File No: R/2015/21/C  
Your Ref: SSD 7080

**RE: Proposed mixed use residential and retail development at 80-88 Regent Street, Redfern (SSD 7080) – Revised Response to Submissions (RTS)**

## Attachment A: Review of Response to Council Submission

Job No.	Drawing No.	Revision
5359	DA-0501	/ 8

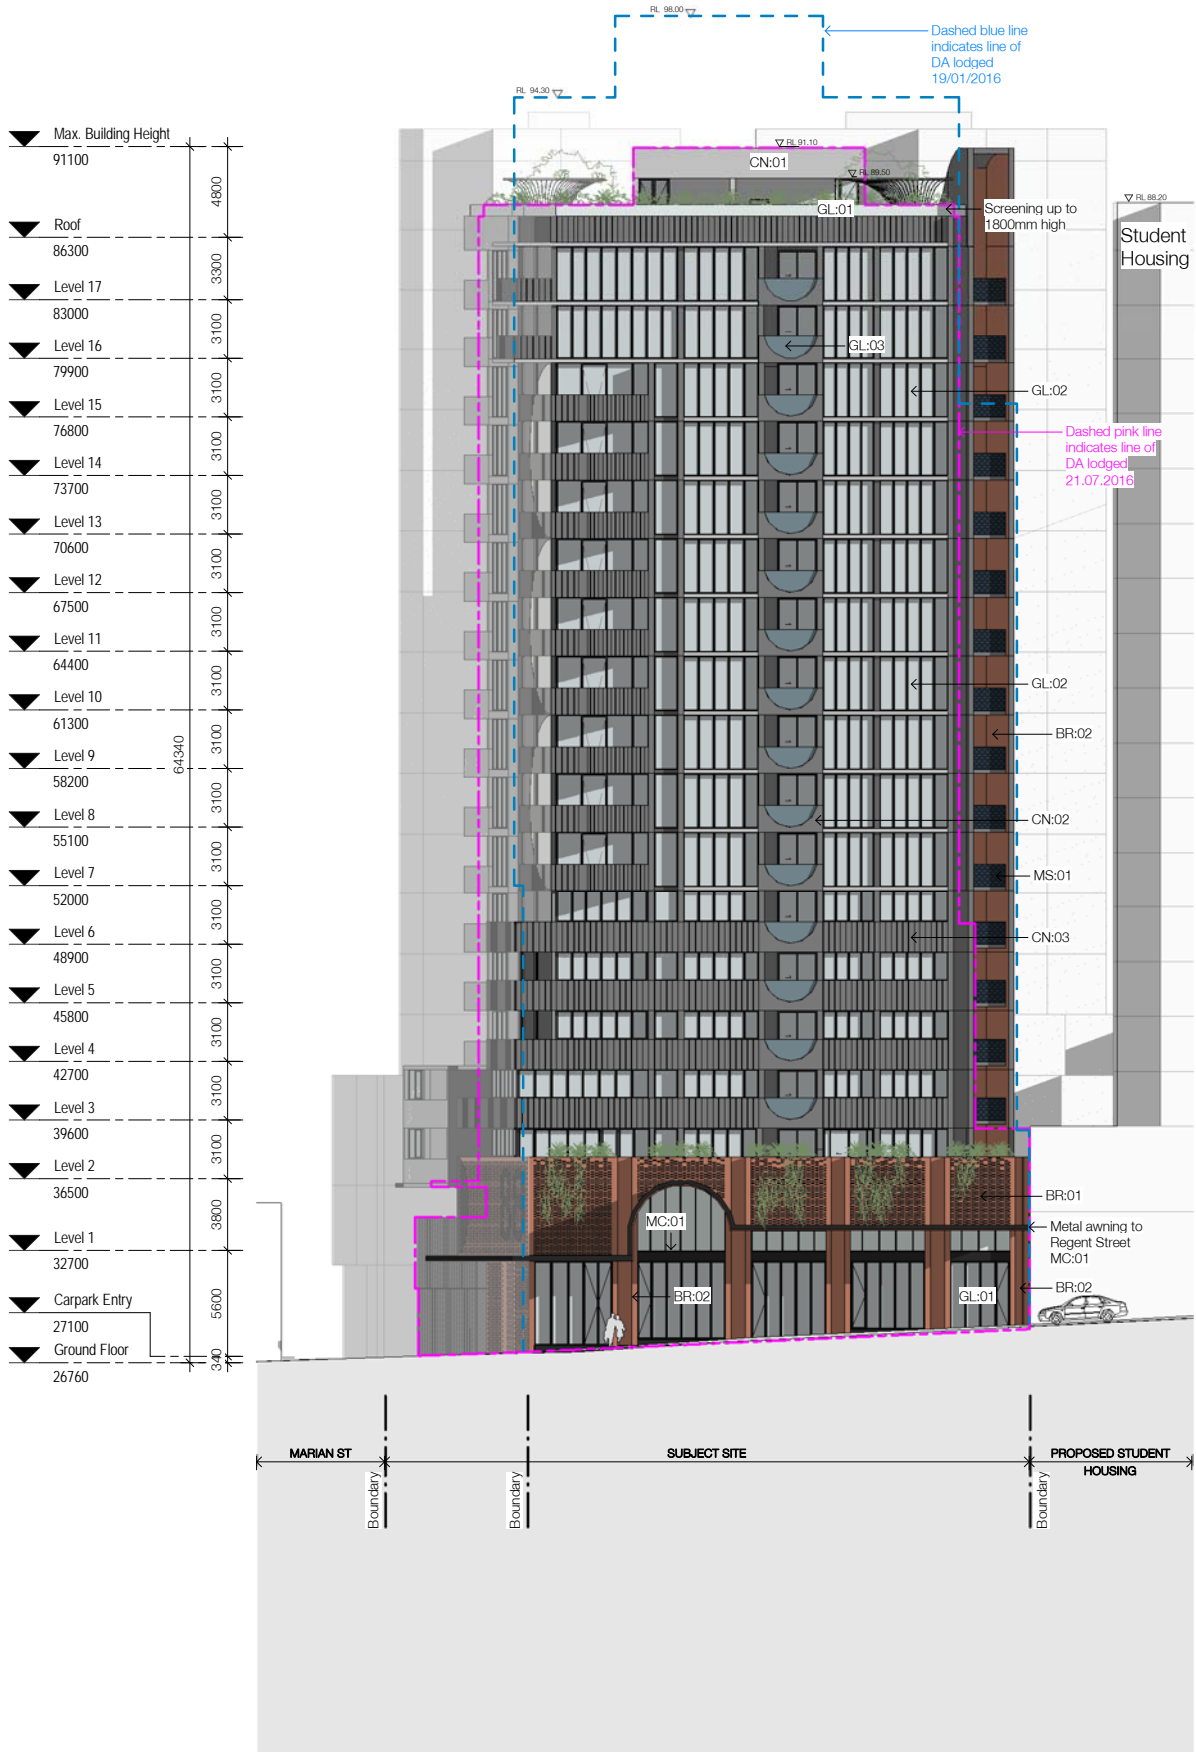
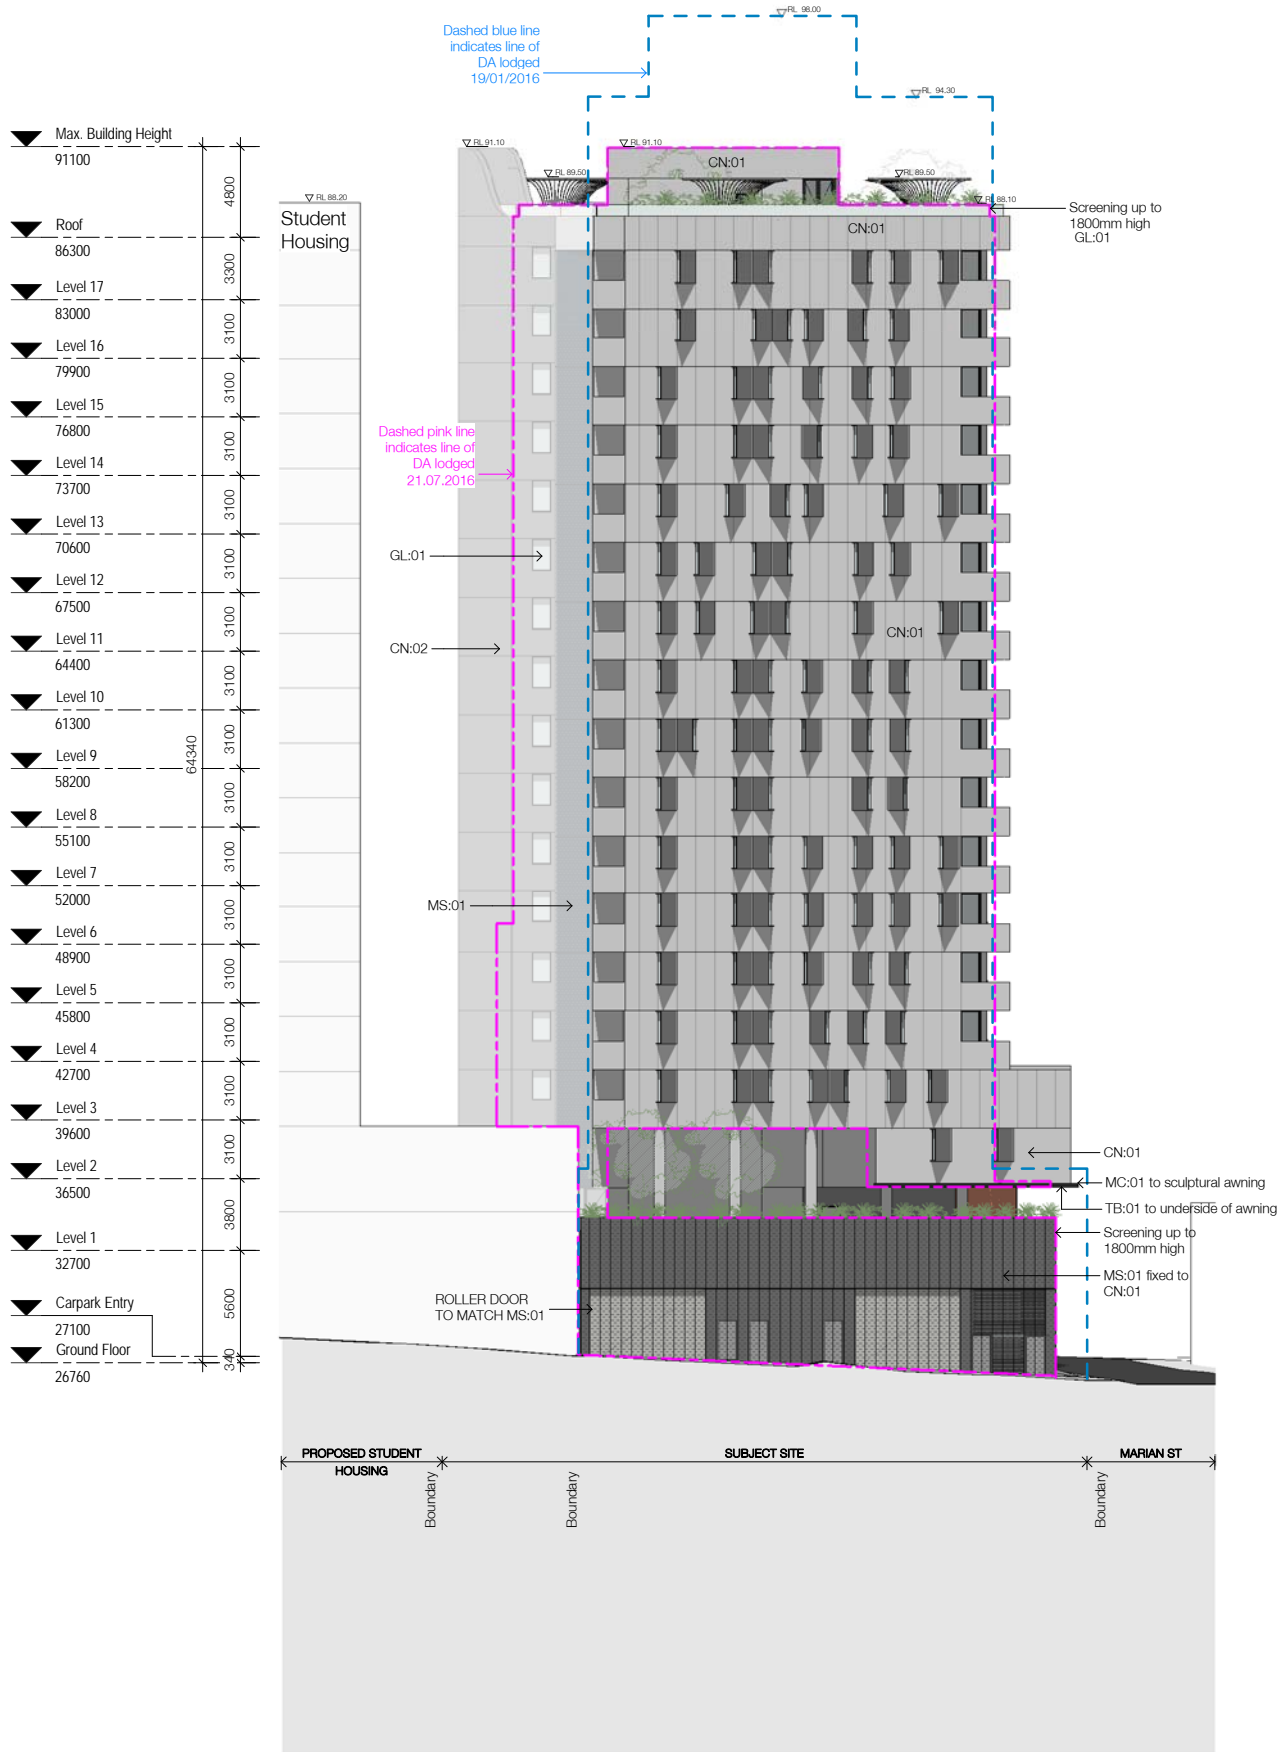
- The Regent Street elevations show floor to ceiling glass to bedrooms and living rooms. For example, Apartments 7.01 and 7.02. It is not clear how these rooms achieve natural ventilation in accordance with the ADG as no window types have been shown to these habitable rooms.

- The shopfront awning on Regent Street appears to be quite high (approximately 6m above the footpath). This height is not in keeping with the awnings at 'Iglu' site and other buildings within the street block. The tall awning may not be able to provide proper weather protection to the pedestrians. Furthermore, as the awning bisects the eastern façade of the podium, it results in a disproportional first level wall height of the building. In other words, the shopfront is too tall but the first level hit-and-miss brickwork above the awning is too low. The awning is to be lowered to align with the first floor level and the design of the façade is to be amended accordingly.
